From: Mike Burford
Sent: 07 February 2012 17:07
To: Planningecons
Subject: RE: Planning Consultation on: AB/8/12/
[Engineers comments on AB/8/12/](#)

APPLICATION AB/8/12/
NO:

Registered: 01-FEB-12
Site Land adj 84 Maltravers Street Aundel BN18 9DS
Address:

Description of Works: Erection of 1 no. new dwelling

Proposed Floor Plans

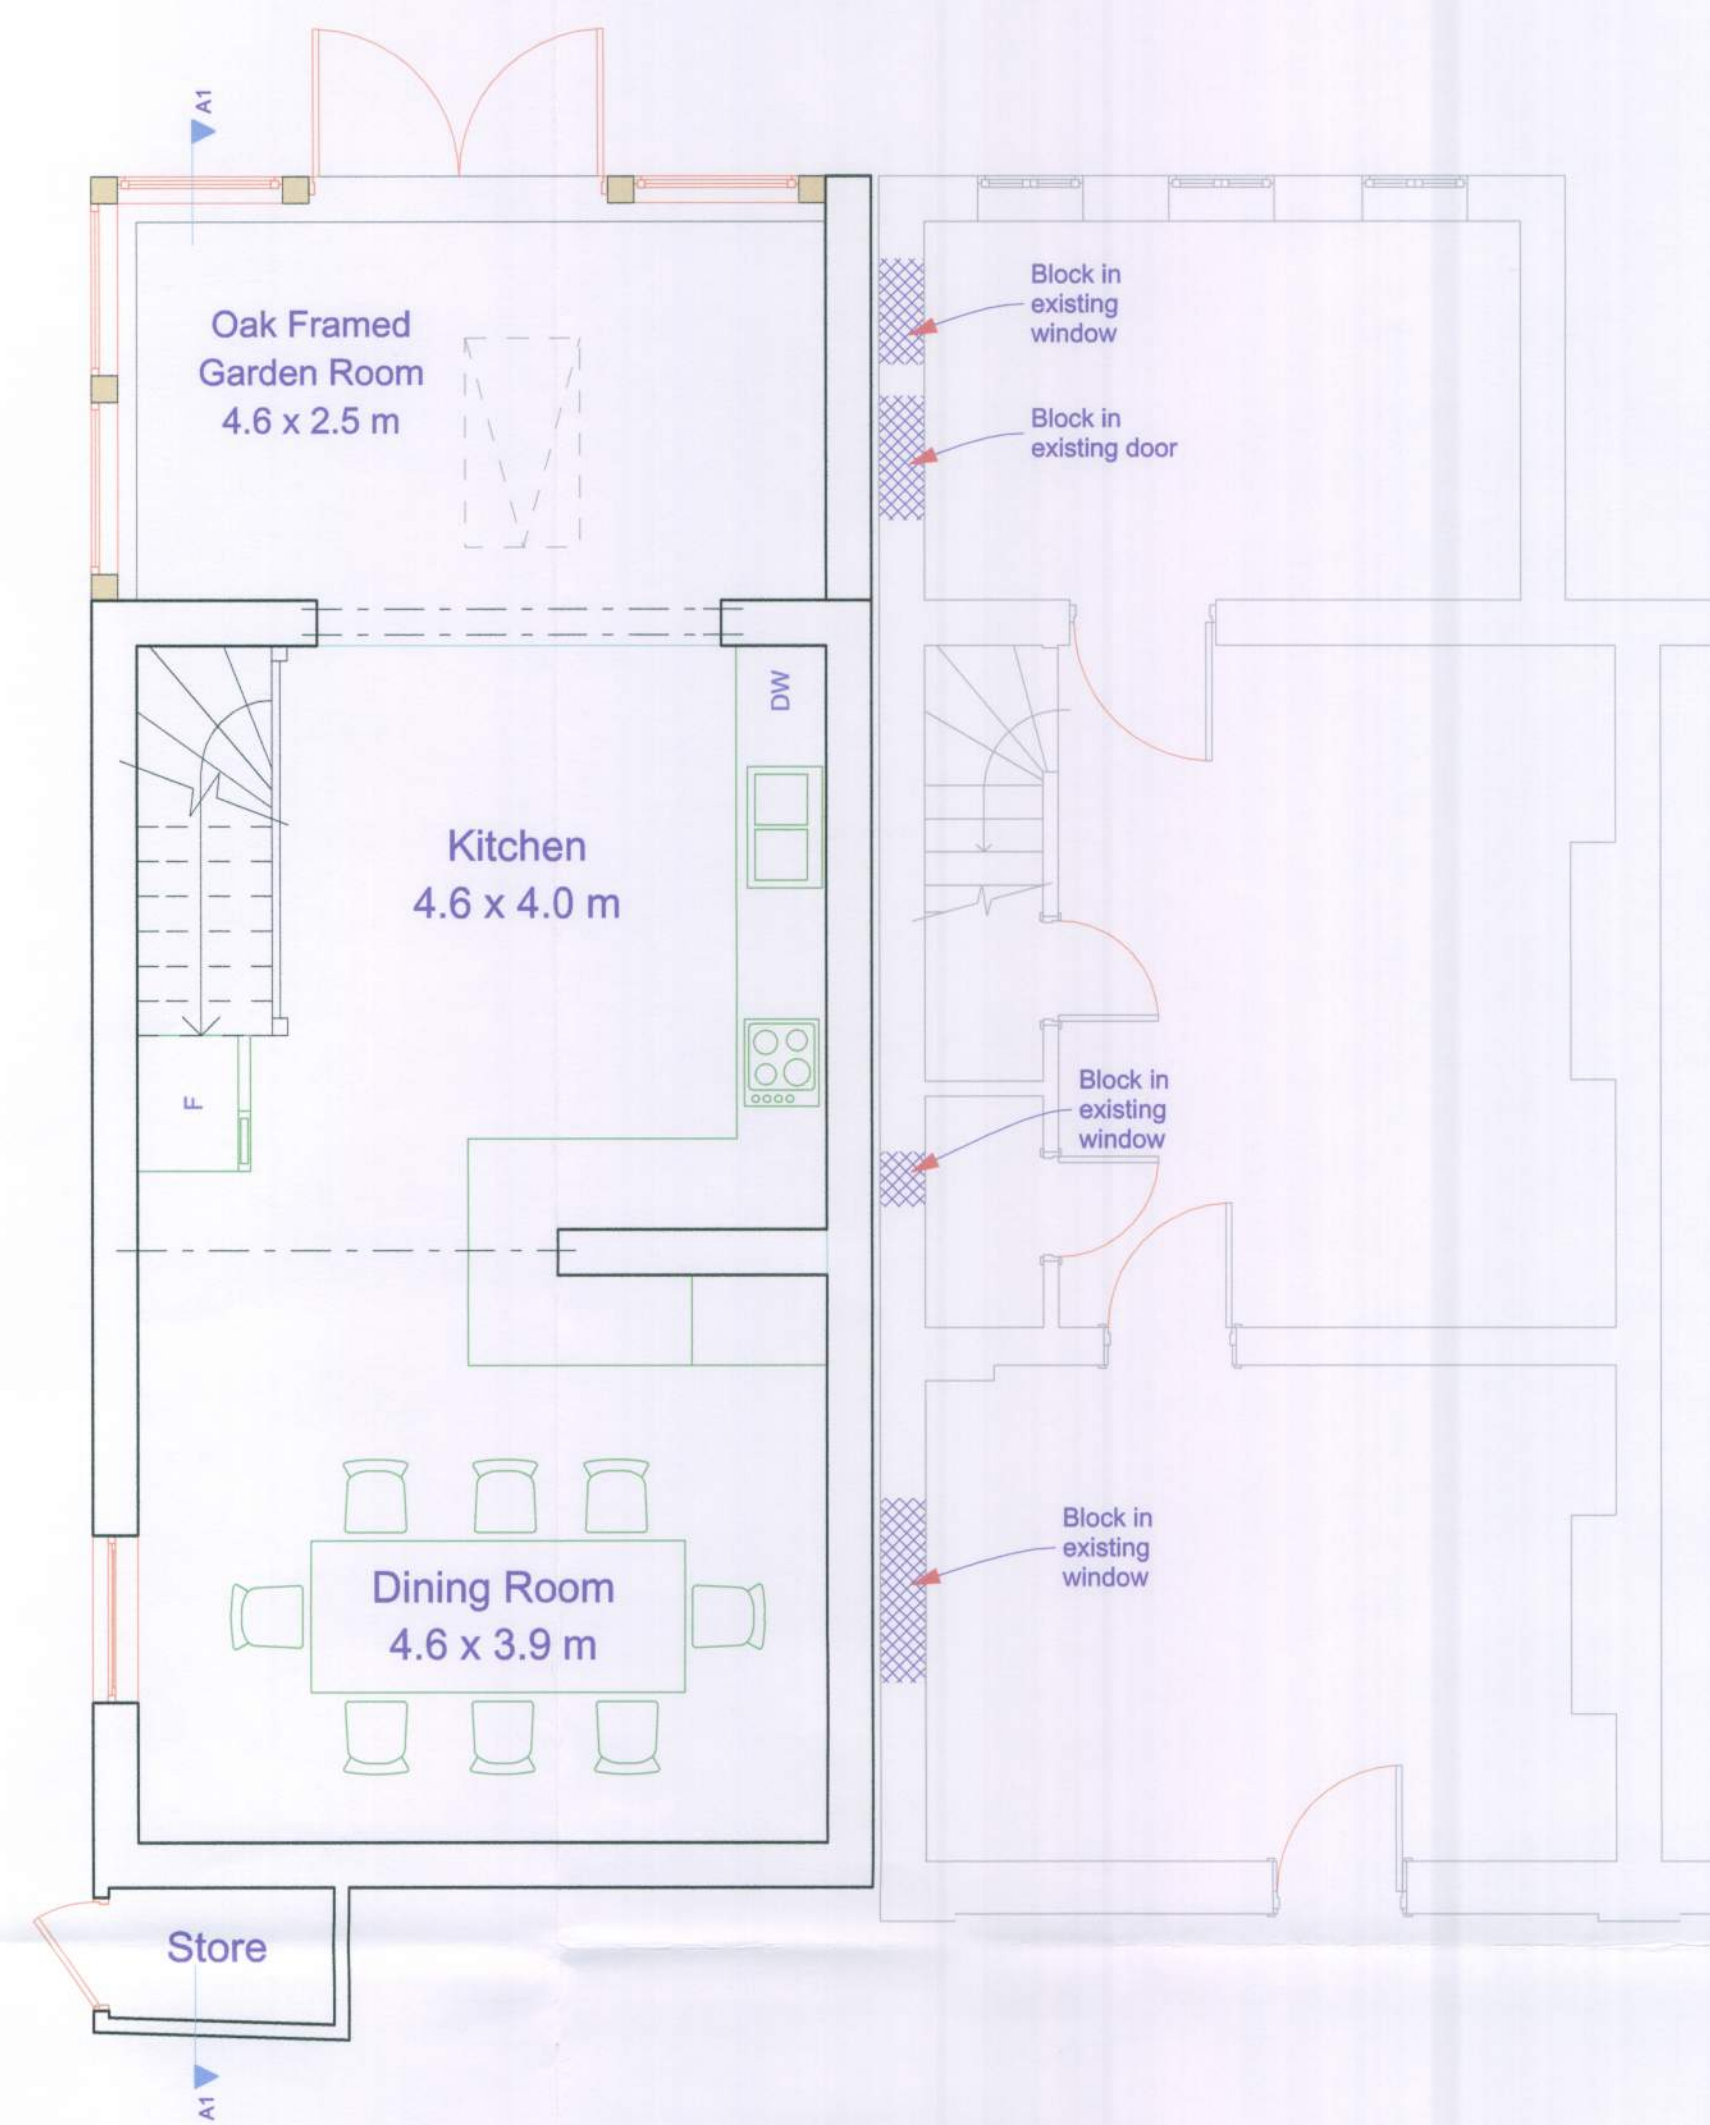
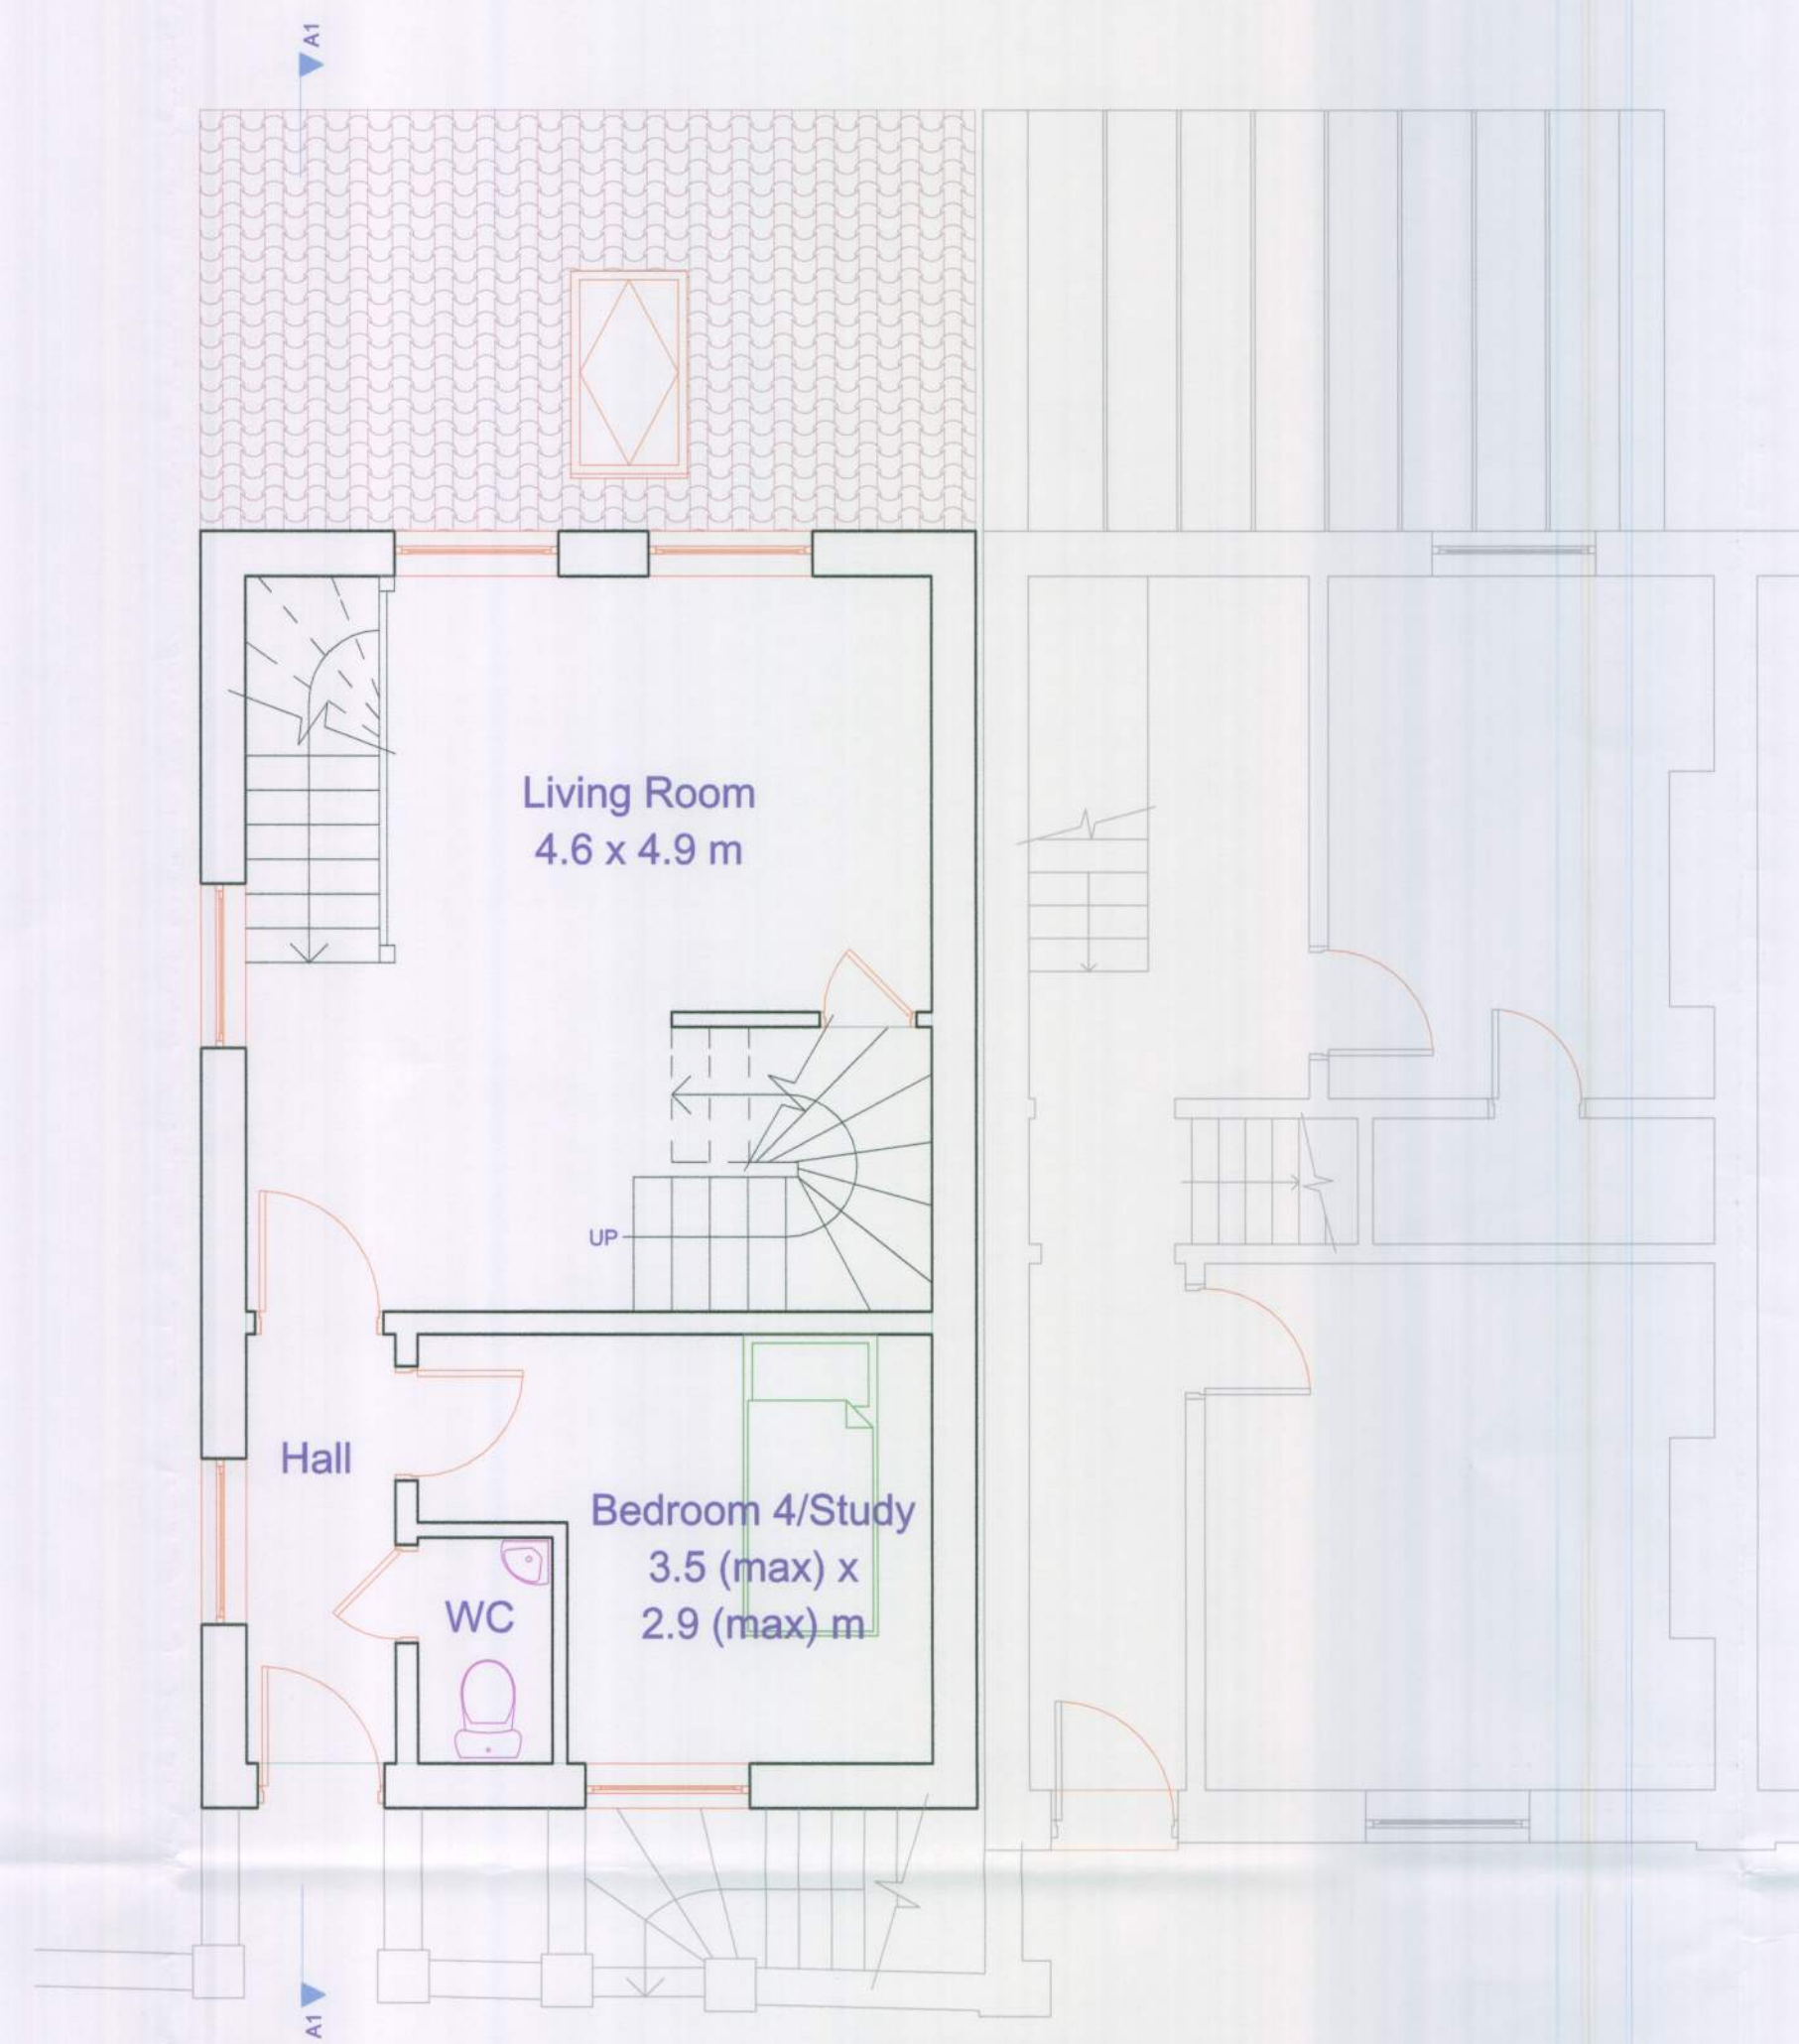
The proposed building is over or very close to a foul and surface water sewer. To build this close to the sewer the applicant would require permission from Southern Water.
